CITY OF ALBUQUERQUE

October 18, 2024

**RE: Skyview West
Grading & Drainage Plan
Engineer's Stamp Date: 09/25/2024 (most recent)
Hydrology File: K10D070**

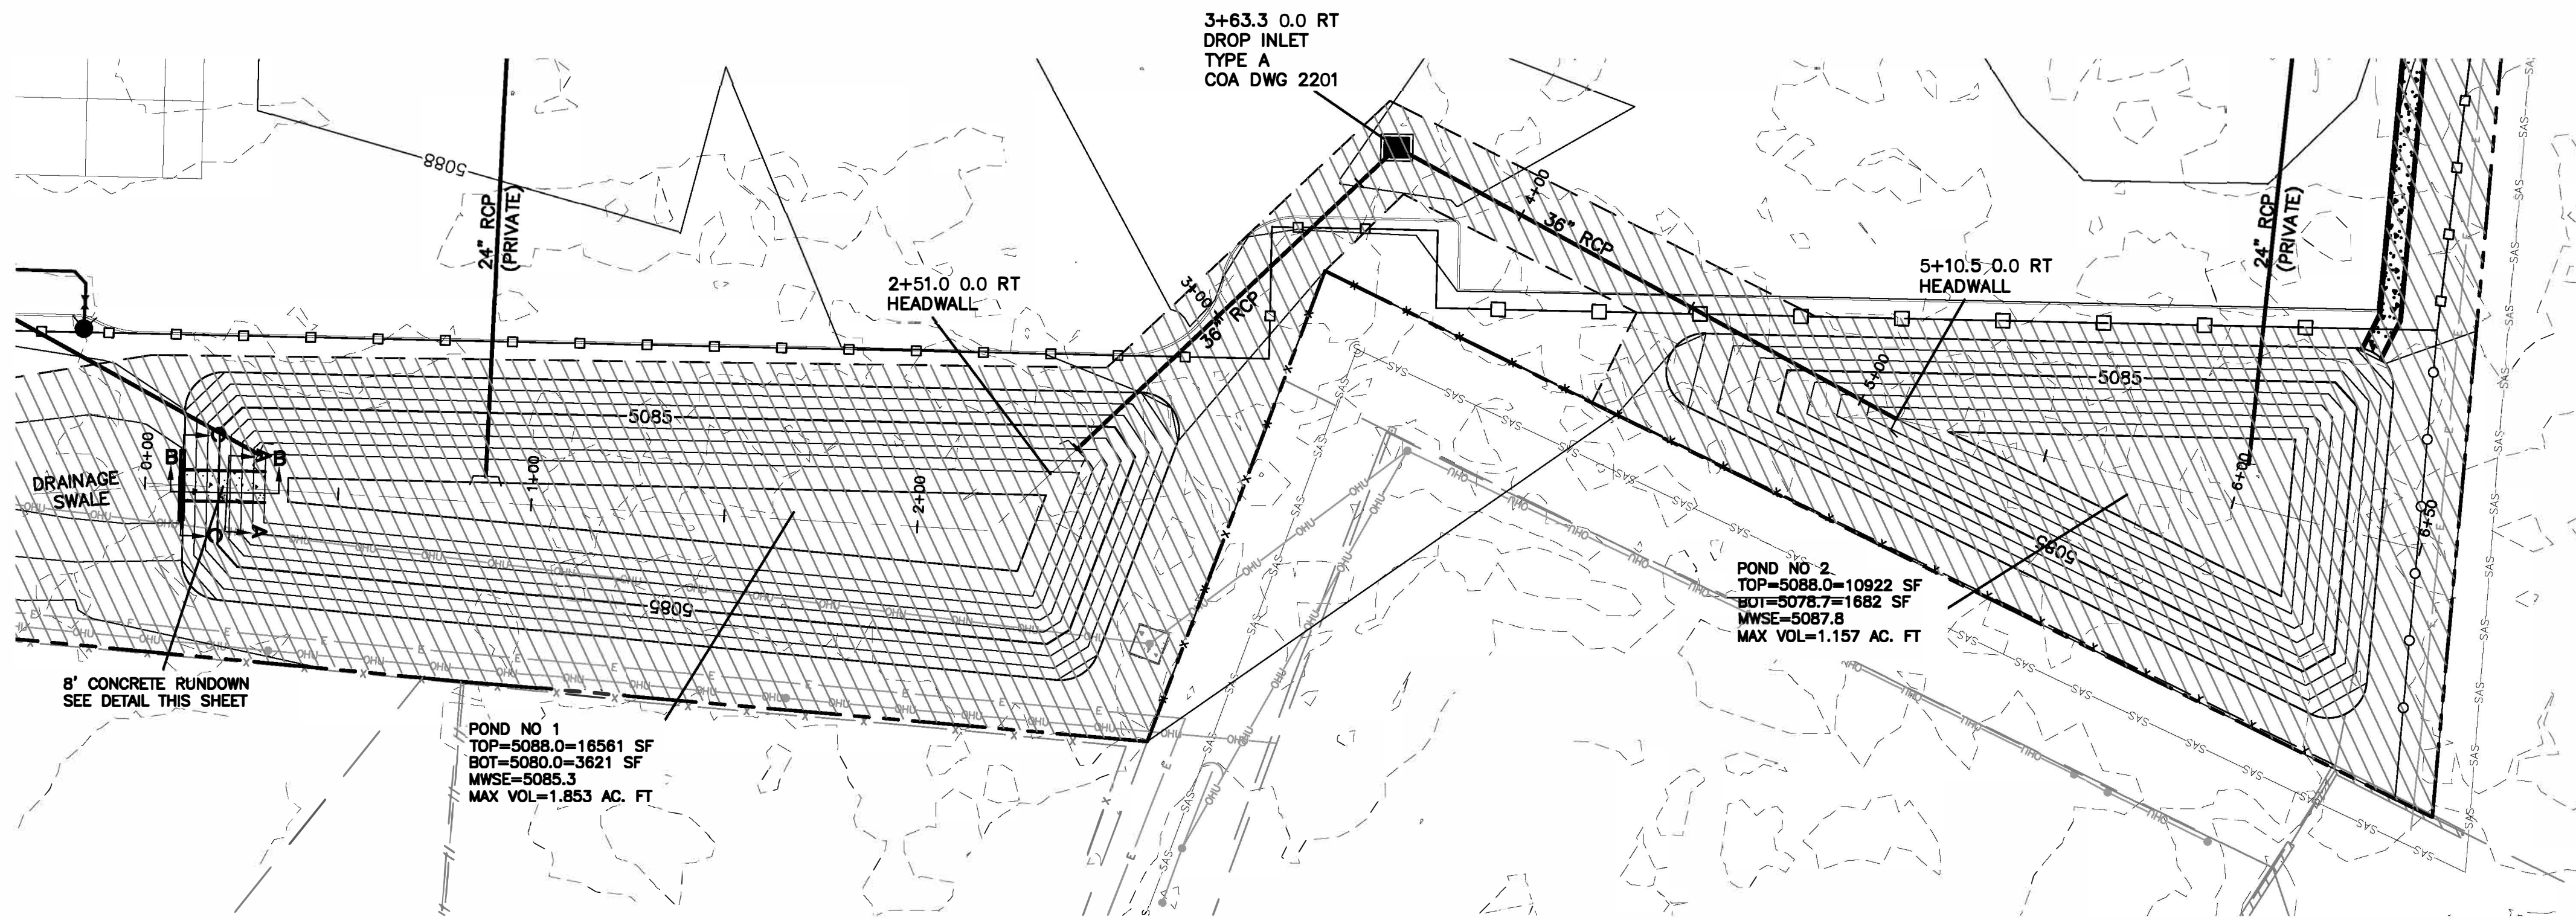
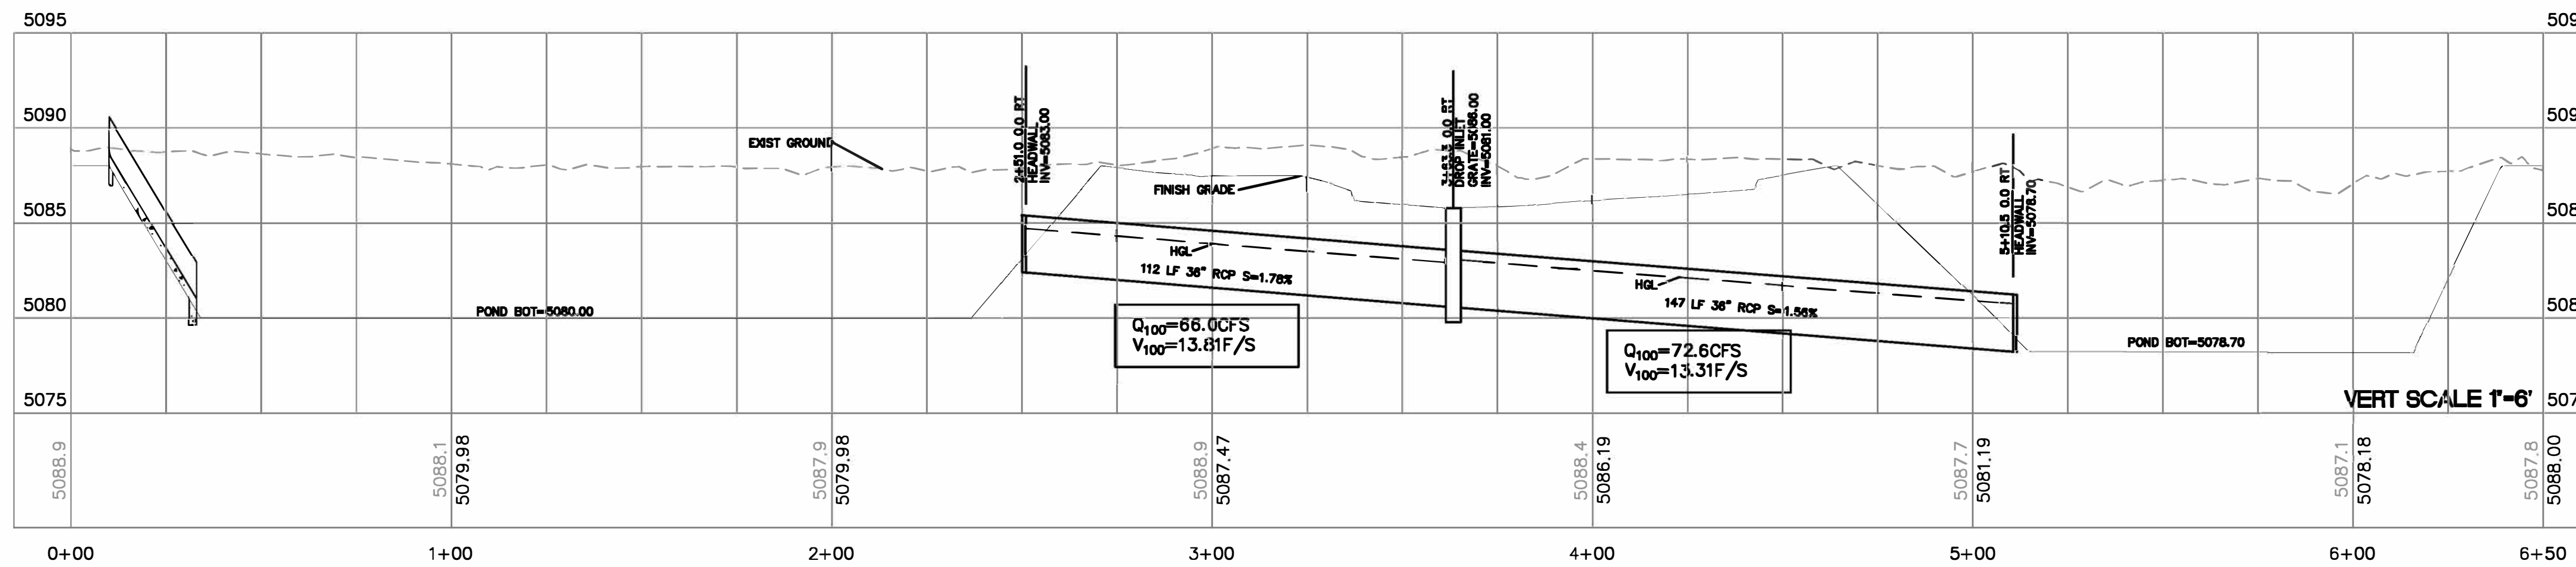
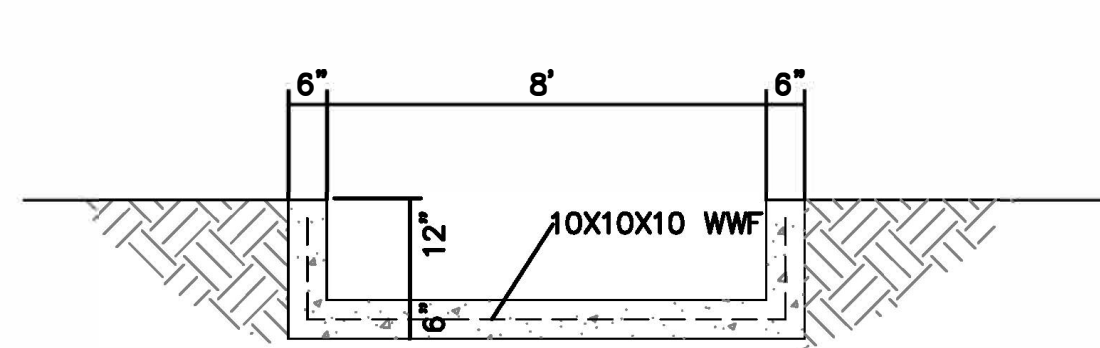
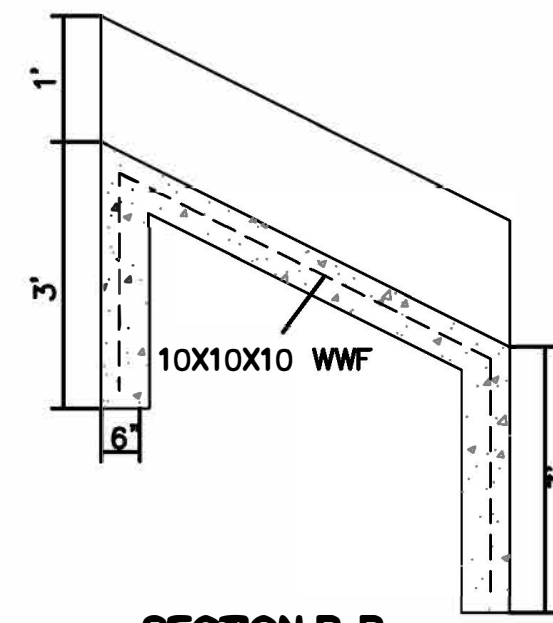
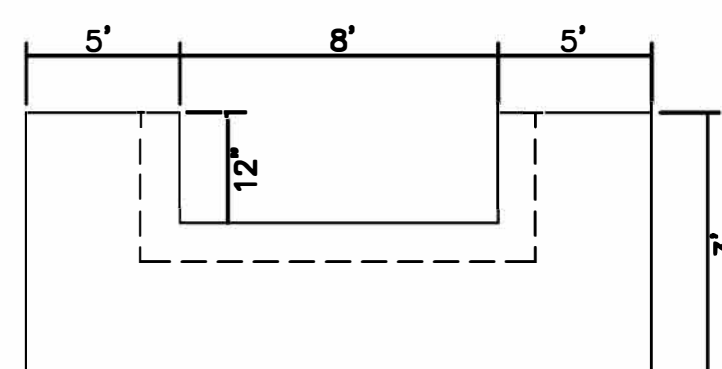
3. Sheet GR-2: Review and revise all information and quantities for proposed 36" dia. RCP storm drains between proposed Pond No. 1 and Pond No. 2.
4. Sheet GR-3: Review and revise stationing for proposed concrete channel and confirm proposed Pond No. 2 outfall invert elevation.

ENGINEER'S SEAL RONALD R. BOHANNAN P.E. #7868	SKYVIEW WEST ALBUQUERQUE, NM	DRAWN BY pm
	GRADING PLAN	DATE 10-21-24
 TERRA WEST, LLC 5571 MIDWAY PARK PL NE ALBUQUERQUE, NEW MEXICO 87109 (505) 858-3100 www.tierrawestllc.com	SHEET # GR-1	JOB # 2023062

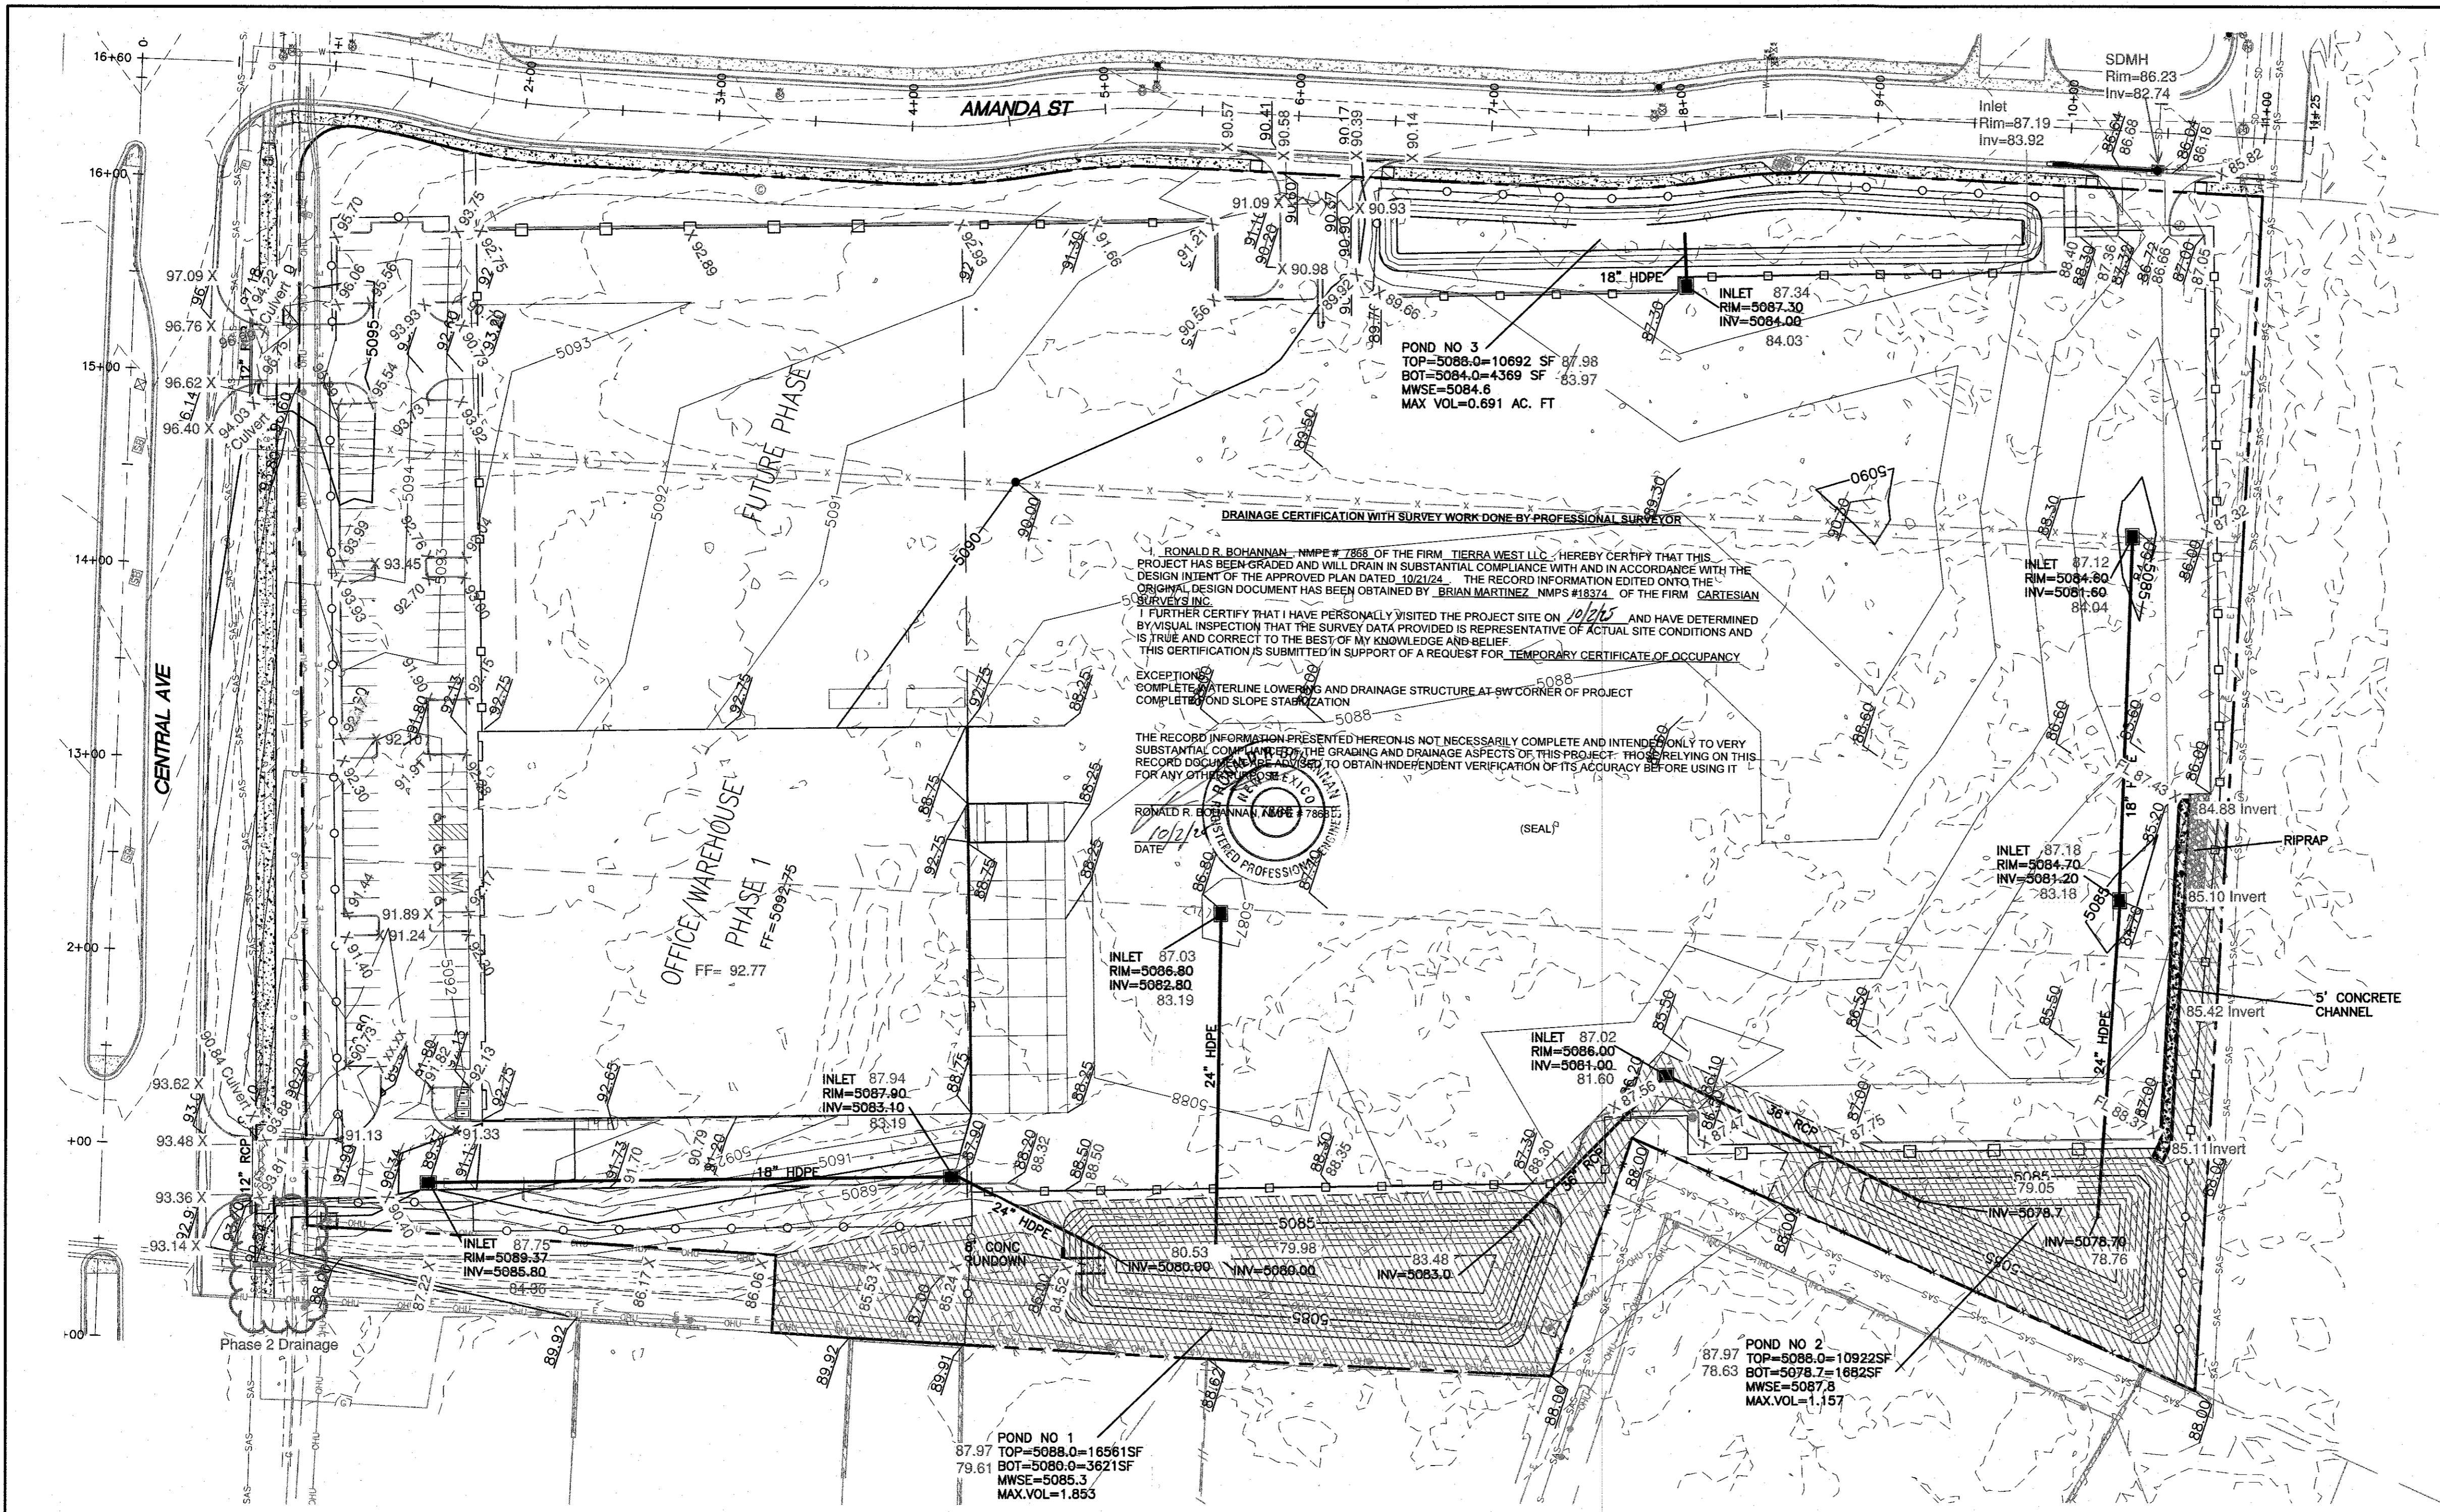
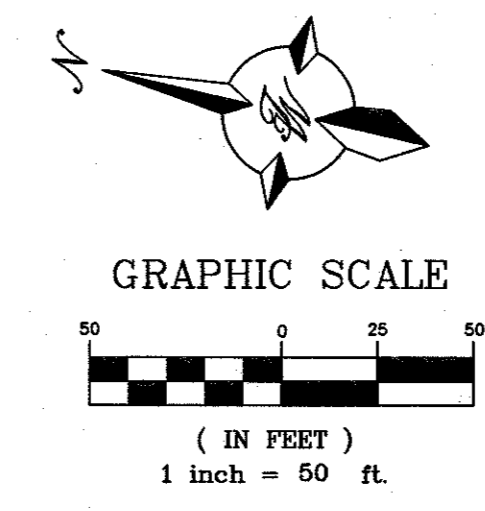
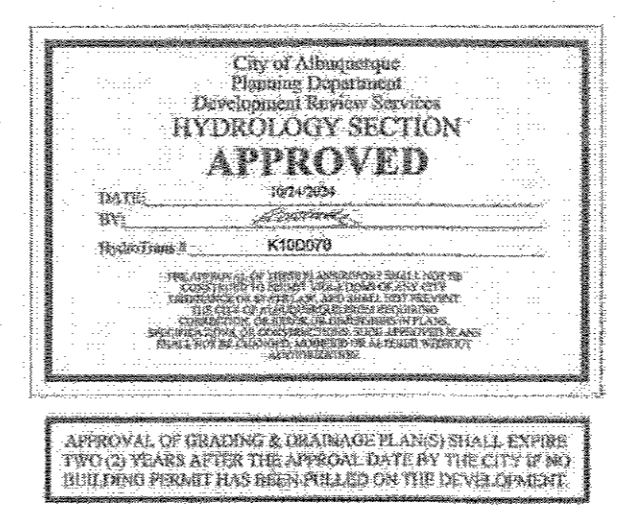
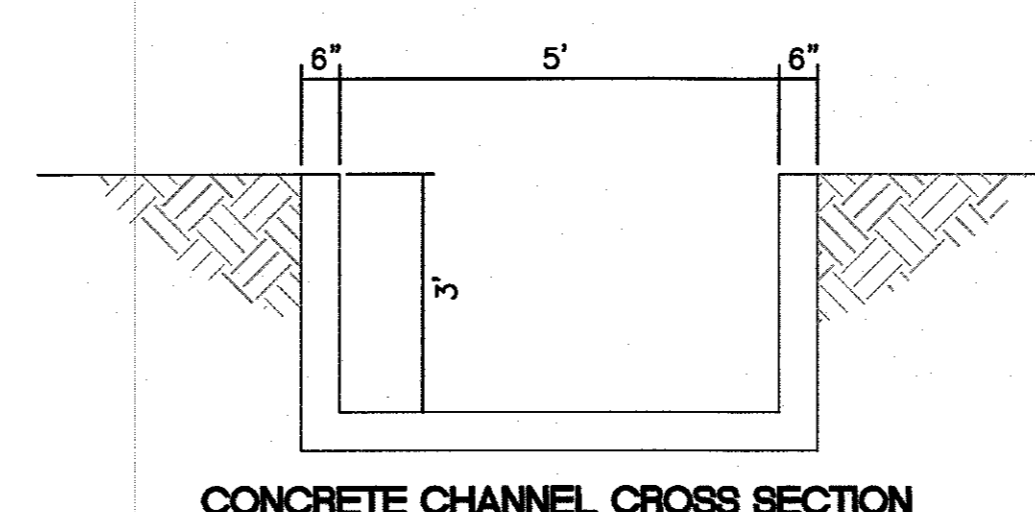
1. Sheet GR-1: Review and revise all notes to comply with appropriate Bernalillo County Specifications and Regulations.
2. Sheet GR-1: Review and revise all information and quantities for proposed Pond No. 1 and Pond No. 2.
